SSD 8517 | Mod 3 | Response to RFI

Proposed Level 1 Plan, location of change indicated in red (deletion of studwork wall)

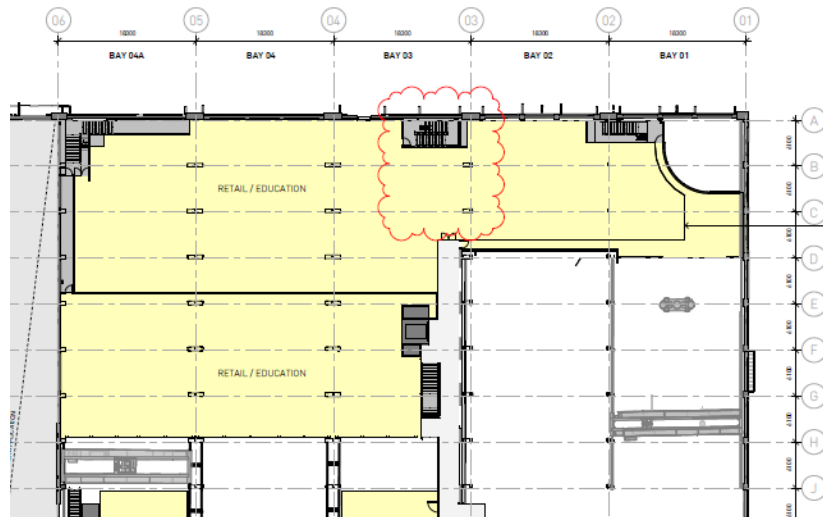
I note that in the original Modification Application for Mod 3 to SSD 8517, a wall on level 1 was deleted in the submitted architectural drawings (see **Figure 1**). On behalf of Mirvac, I confirm that this wall is proposed to be deleted as part of the Modification Application.

The reason for the deletion of this wall is to enable a larger tenancy area. The wall, as originally approved, was to be a new internal studwork wall and was not part of the original heritage fabric. The deletion of this wall does not give rise to any change to the planning assessment in the original Modification Application, and is considered acceptable.
